From: Amanda Scholes on behalf of Planning.Responses
Sent: 02 July 2018 09:10
To: Planning Scanning
Subject: FW: Planning Consultation on: LU/76/18/PL

NOTIFICATION FROM ARUN DISTRICT COUNCIL
Town & Country Planning Act 1990 (as amended)
Town and Country Planning (Development Management Procedure) (England) Order 2015
Planning Permission
APPLICATION LU/76/18/PL
NO:
Registered: 21st May

2018
Site Address: 67 High Street Littlehampton BN17 5EJ
Grid Reference: 502883 102116

Description of Works: 4 No. tables with chairs & awning to front elevation. This application affects the setting of a listed building.

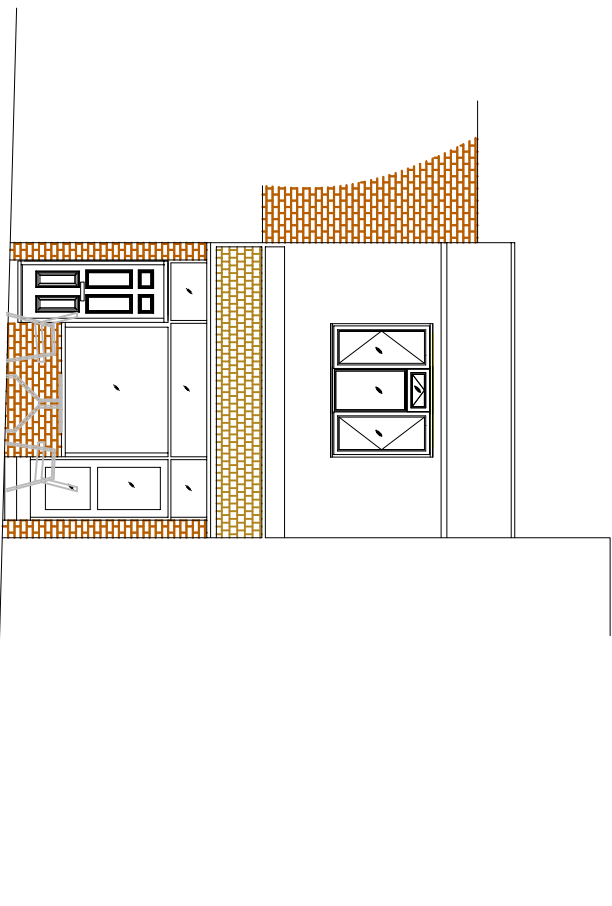
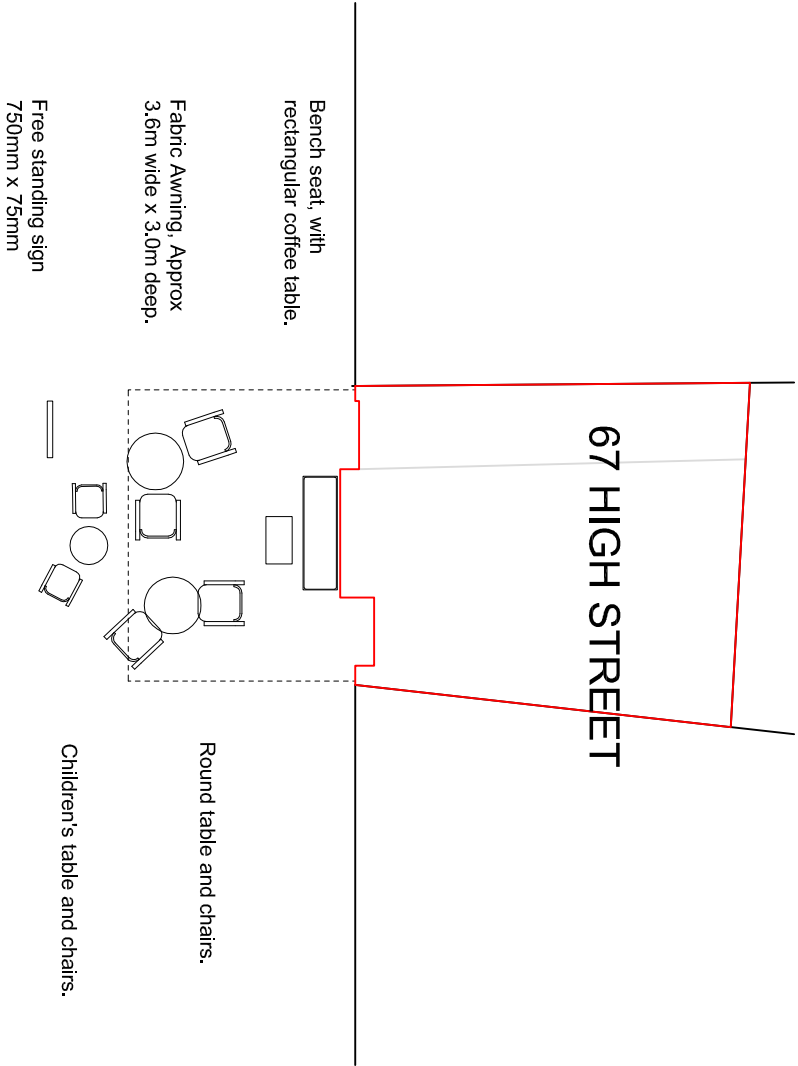
Environmental Health: See My Comments 4th June 2018. I am not aware that Environmental Health have received this application as yet. Nevertheless, I had already spoken with the business owner and explained that the lack of any public WC provision means that the number of seated patrons is therefore limited to 8. This is to include internal and external seating. Furthermore the internal layout means that it would be inappropriate for any patron to use the existing first floor staff WC facility.

Should the applicant wish to retain any internal seating area then this application for 4 tables externally (of not more than 2 seats to each) would be unsuitable.
